Consultation Response from: KC Environmental Health (Pollution & Noise Control)
2025/91674 - 151 Heckmondwike Road, Dewsbury Moor, Dewsbury, WF13 3NS
Variation of conditions 2 (plans) on previous permission 2022/92230 for reserved matters application pursuant to outline permission 2021/91801 for erection of petrol filling station
Responding Date:
30 October 2025

Responding Officer:
Mohammed Nasim

Responding Ref:
WK202531900

Client
Walker Design
 Project
Heckmondwike Road, Dewsbury
 Description
Hard Landscape Plan

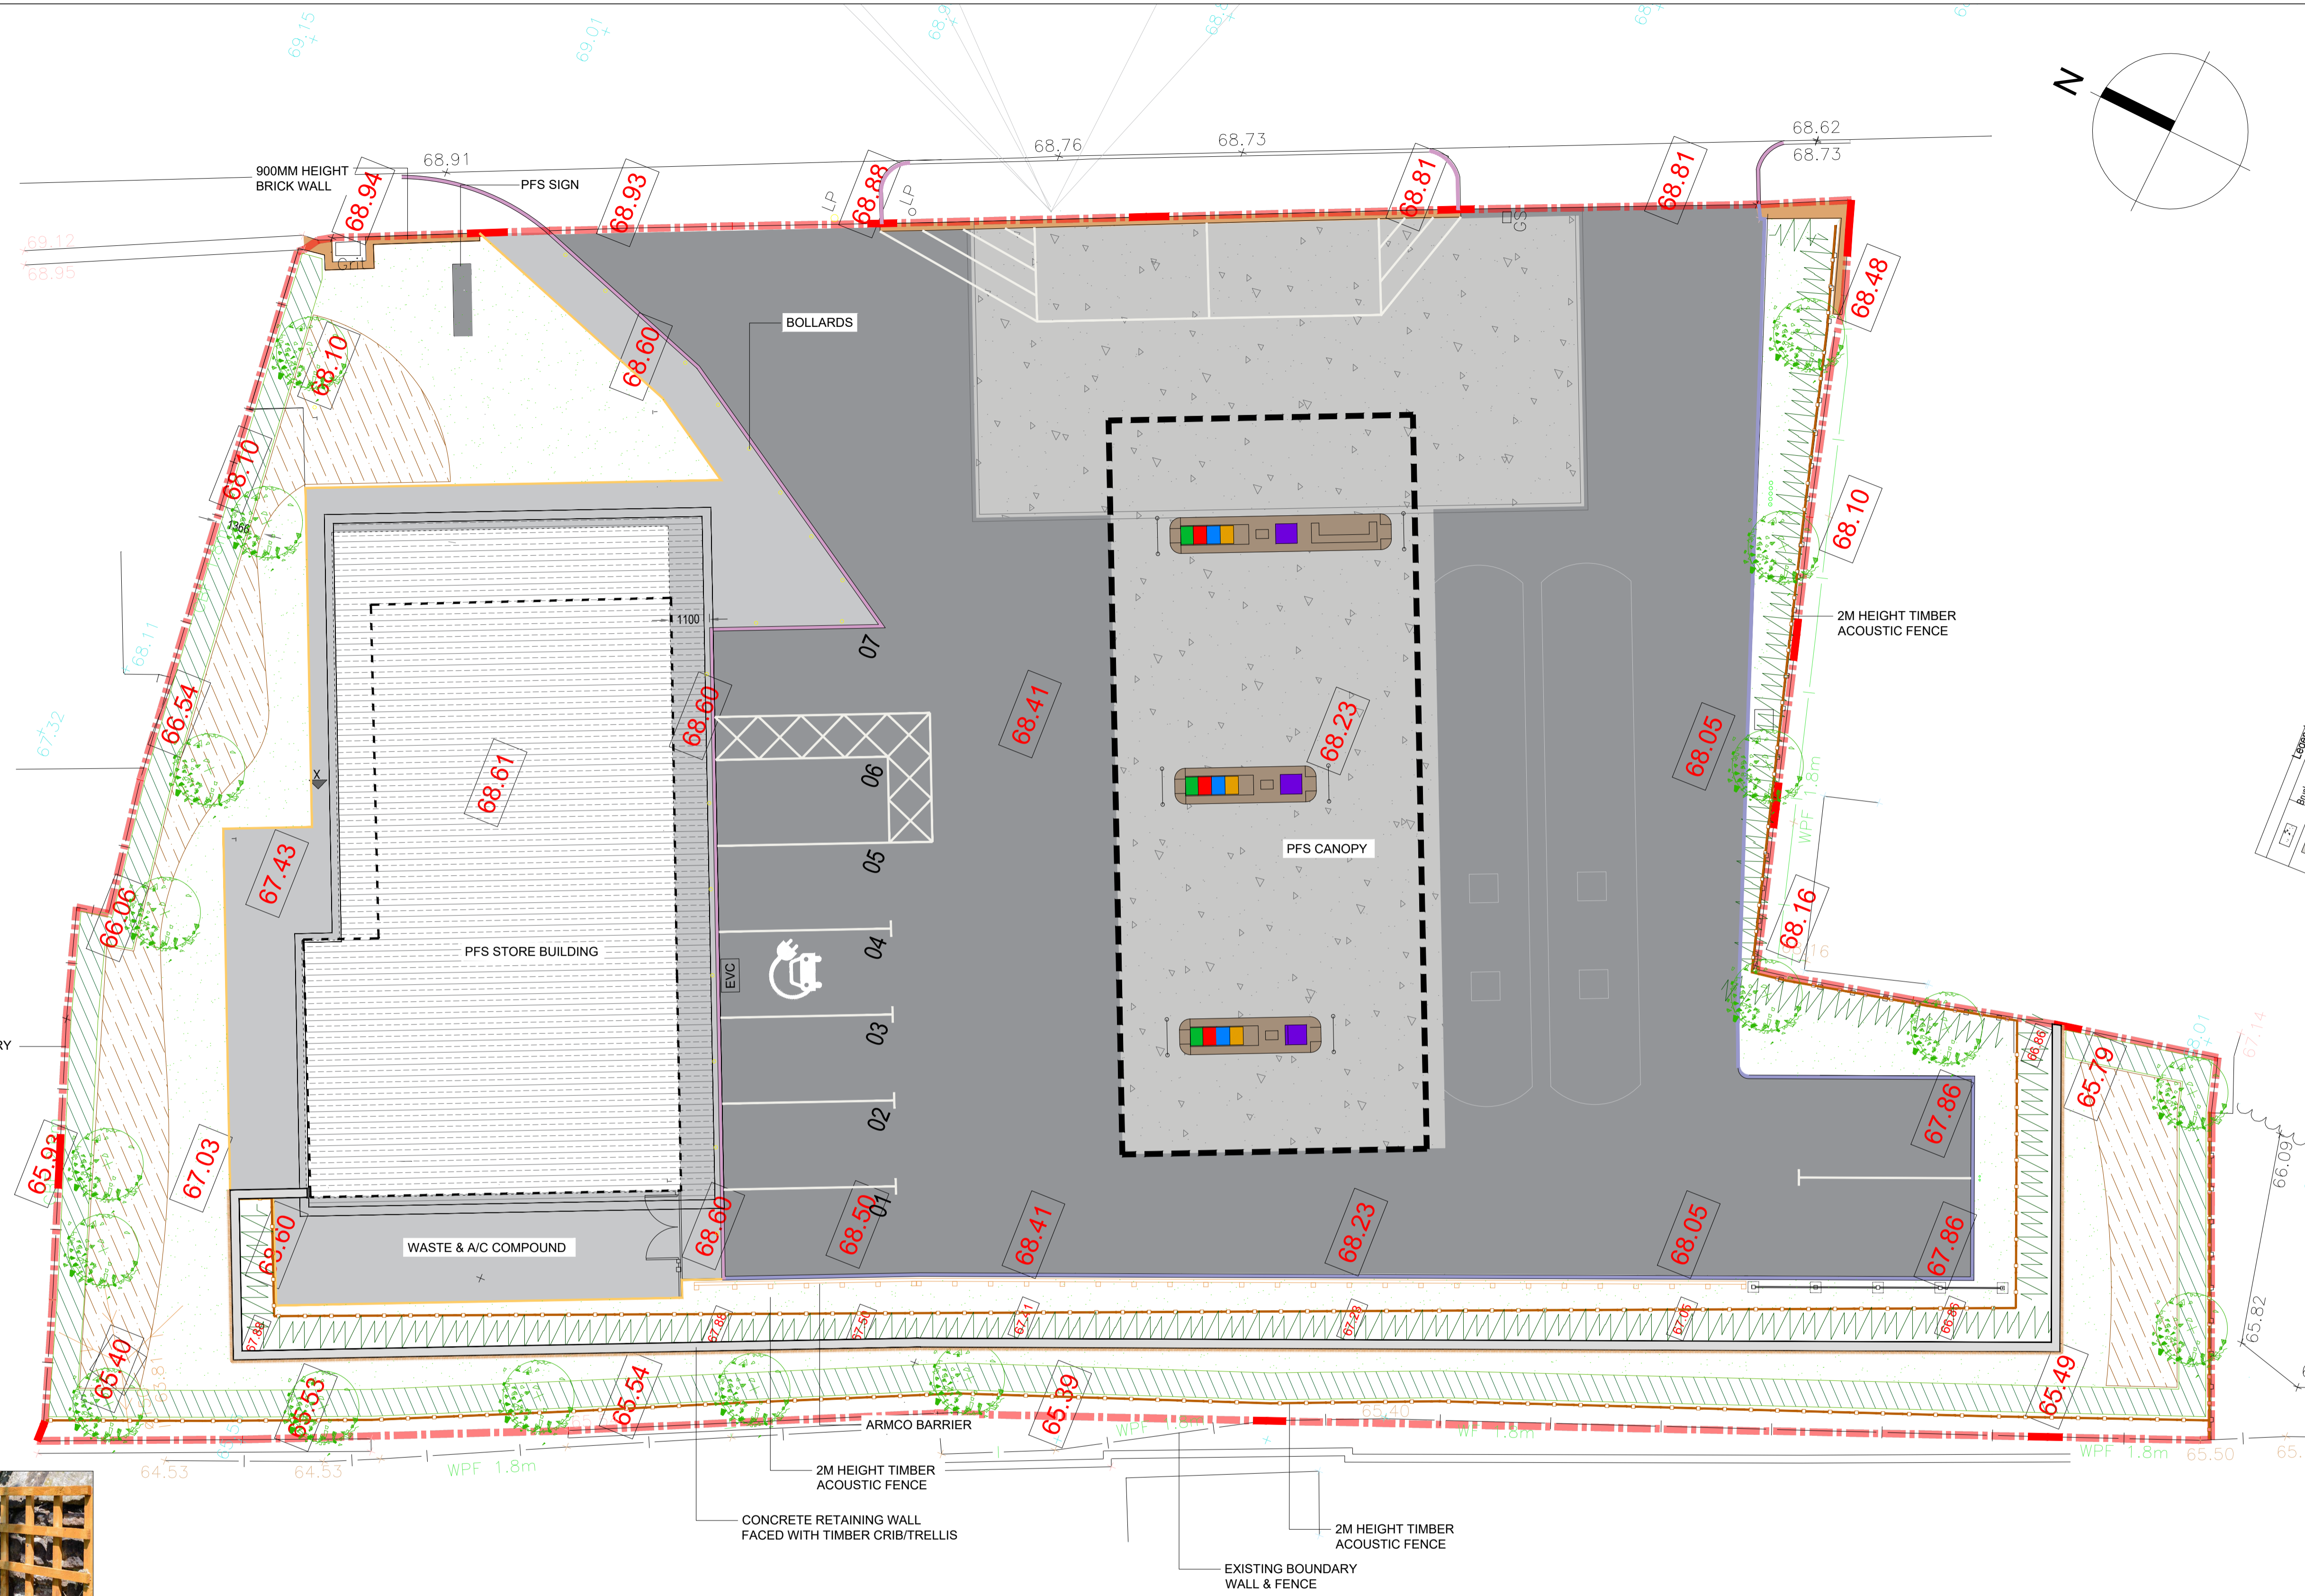
The Planning Officer states the positioning of the acoustic fence may differ from that shown in the approved Noise Impact Assessment as it may be closer to the Armco barriers. We have no objection to this as long as the length, height and construction specification remains.
